DPHI	Comment	Applicant Response
		The GFA drawings have been amended such that the stairs to the commercial units have been excluded from the calculation of GFA. Refer Appendix D .
	<p><i>In relation to the updated design of the residential corridors:</i></p> <ul style="list-style-type: none"> ▪ <i>provide a cross section plan of the residential corridors and typical detailed elevation (at a smaller scale) of the corridors.</i> ▪ <i>discuss the new corridor configuration including (but not limited too) whether the area between the internal wall/door and external façade will be accessible by residents, how the new design allows for acceptable amenity to the corridors as required by the ADG and wind mitigation.</i> 	<p>Drawing DA801 (Rev 01) (<i>Residential Corridor Concept Details</i>) in the revised architectural plans (Appendix E):</p> <ul style="list-style-type: none"> ▪ Provides a cross section and detailed elevation of a typical residential corridor (Level 16, Tower A). ▪ Details the new corridor configuration, including the areas between the internal wall / door and external façades for maintenance access to mechanical plant areas (i.e. not accessible by residents). ▪ Describe

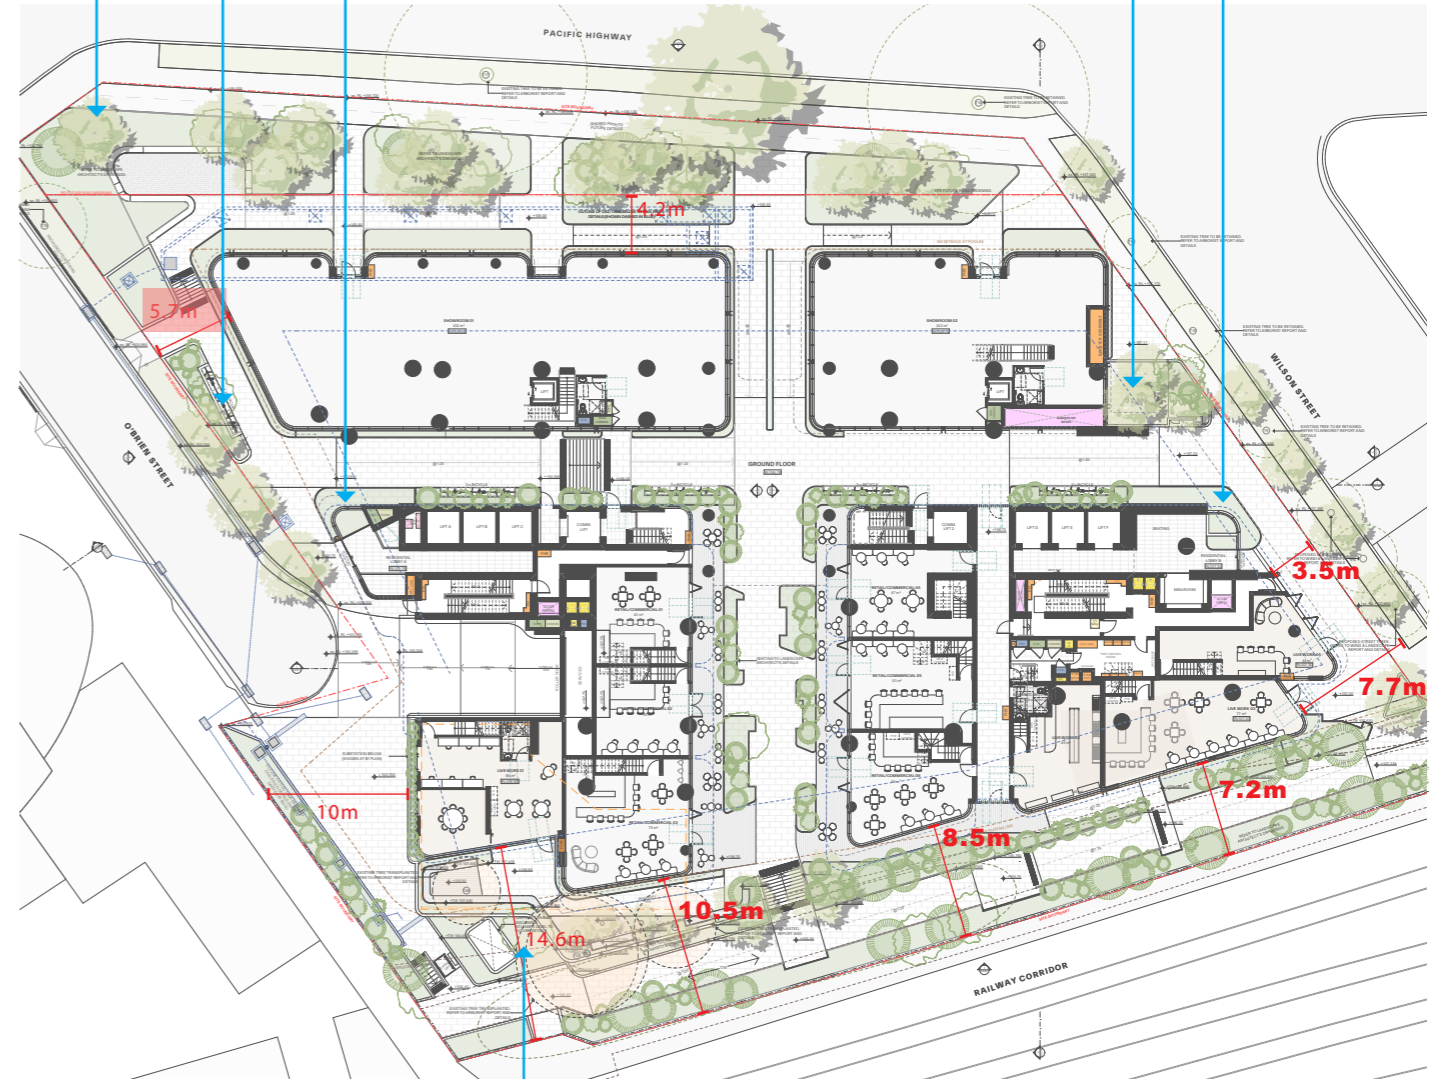
Additional trees are proposed to be removed including a high retention value tree and multiple moderate retention value trees. The RtS must discuss why it is acceptable to remove these trees and what measures were considered for tree retention.

- *Tree 72 (high value) – the updated report advises a temporary substation and the footpath will encroach the SRZ. The location of the footpath has not changed since the EIS. It is also unclear why a temporary substation could not be located elsewhere on the site and why it is acceptable for a temporary item to require removal of a high significance tree.*

- **7 x trees for removal** (Reference # 20(7), 35, 66(x4), 67, 68, 70, and 72). **The trees identified for removal are all located within the subject site.** A total of 7 x replacement trees are required (45L volume pots) to compensate for the removal of High, Moderate, and Low-Moderate Value trees resulting in a canopy replacement of 907 sqm.
- **12 x trees for retention** (Reference # 9, 10, 11, 16, 17, 44, 46, 62, 75, 76, 77, and 78). **The trees identified for retention are located within the public domain and the subject site.**

WASTE MANAGEMENT
BASEMENT LEVEL 1

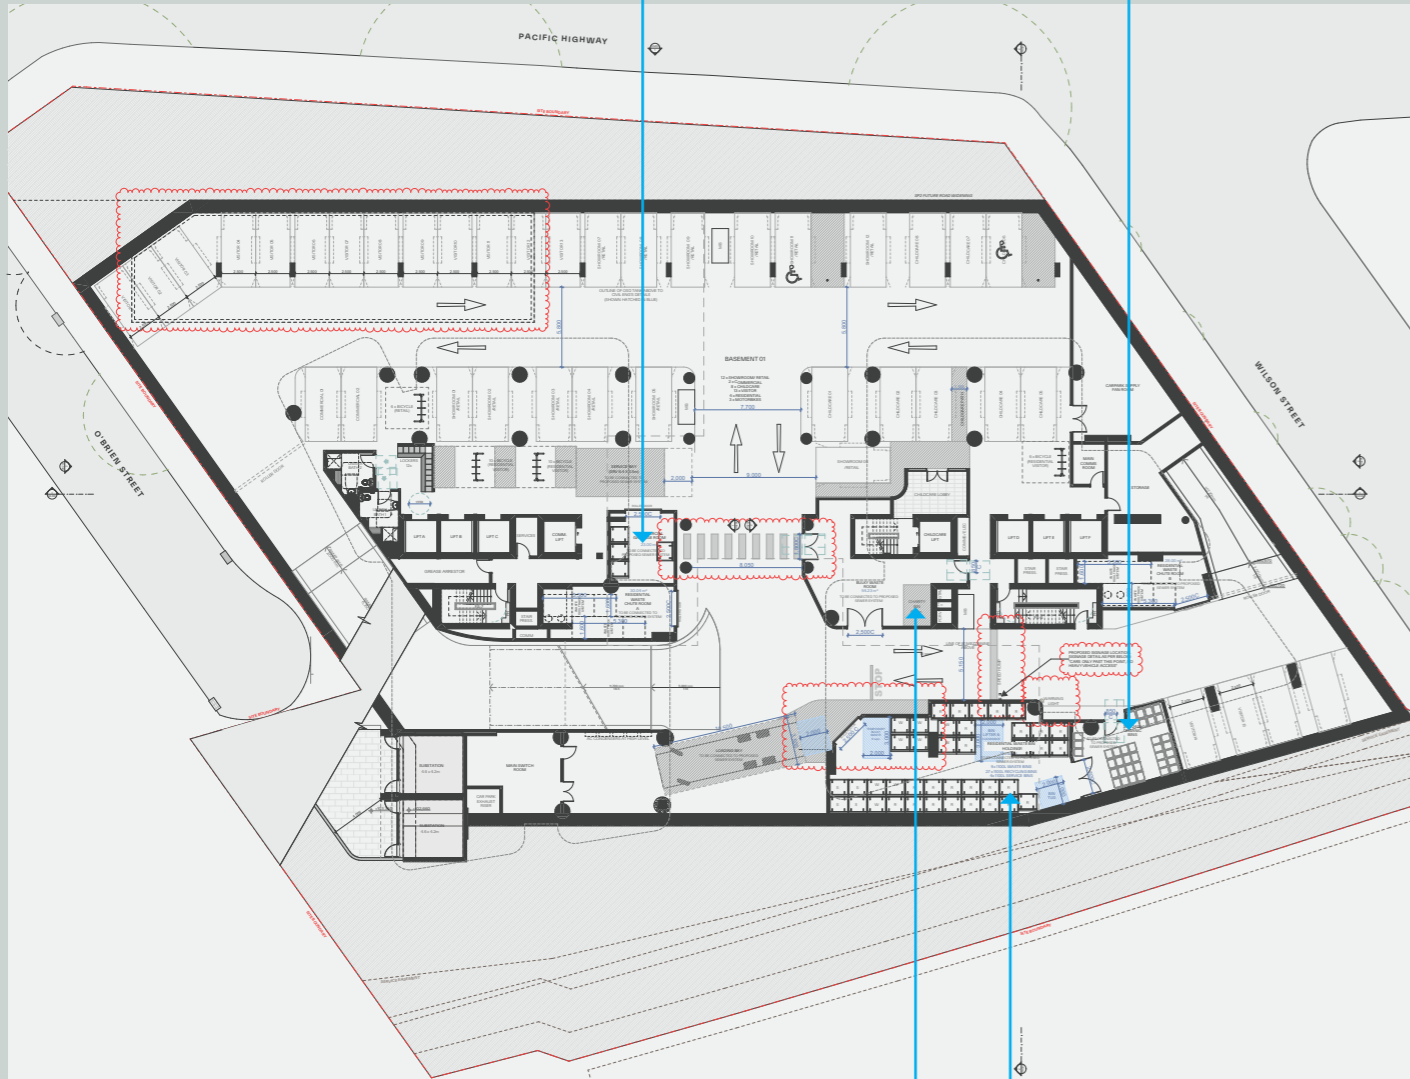
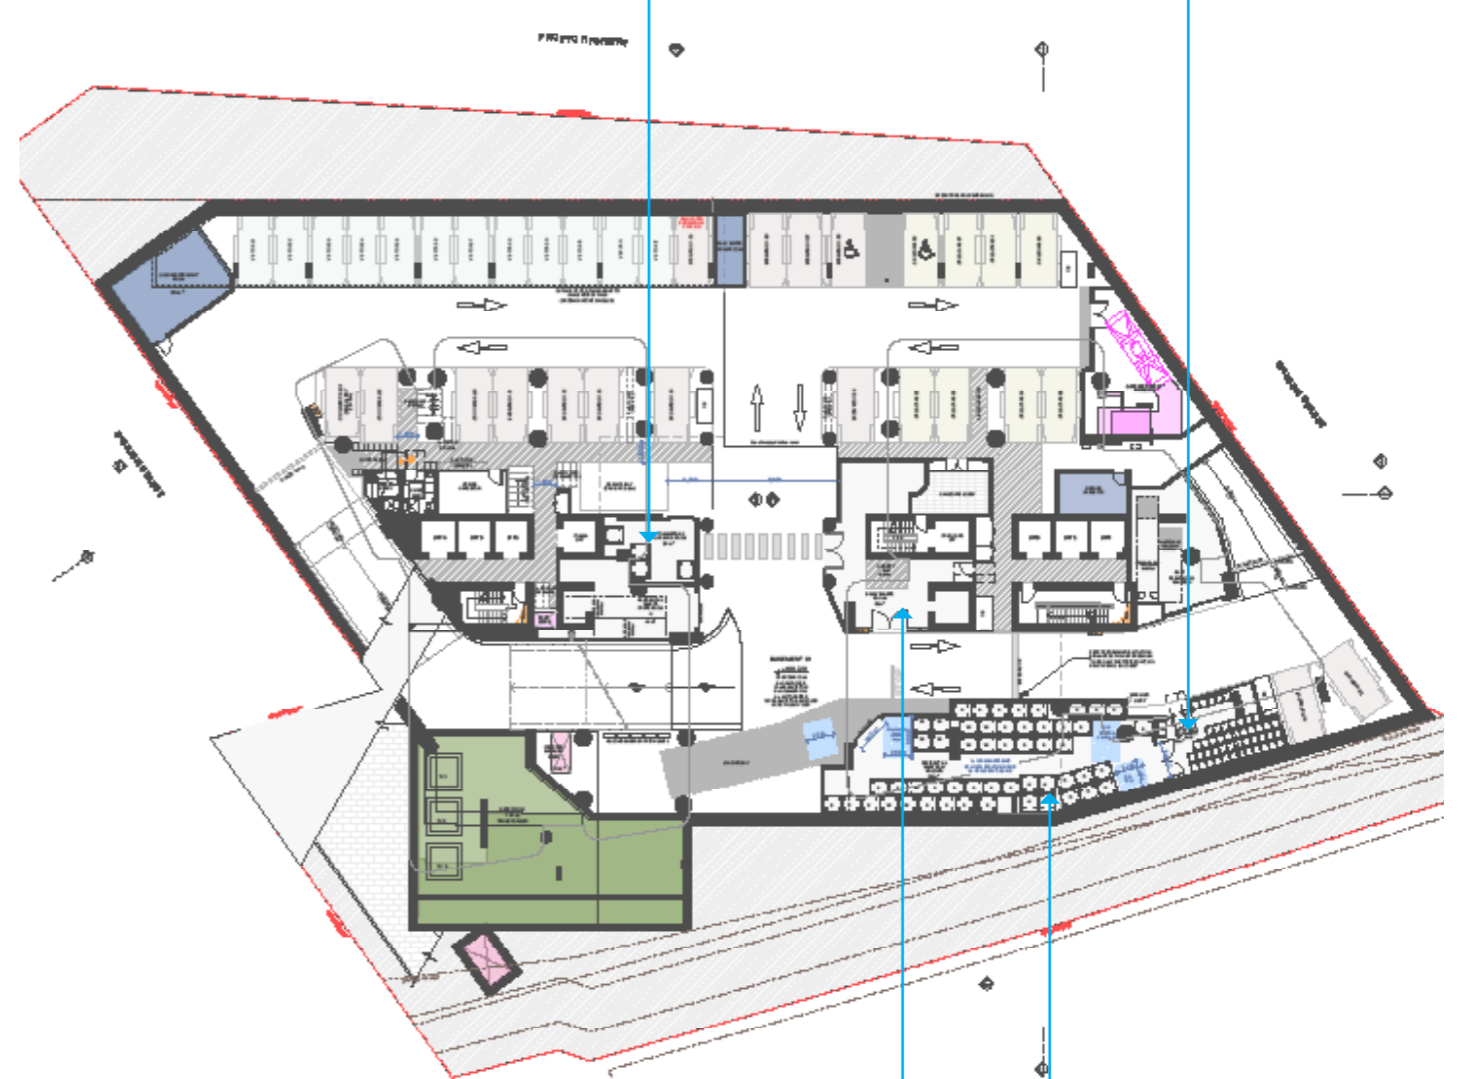
Waste room circulation spaces on Levels 3-35 have not been identified as GFA.

The GFA drawings have been updated to include the waste room circulation spaces at Levels 03 – 35 as GFA (**RTS Appendix D**). A typical plan extract is below.
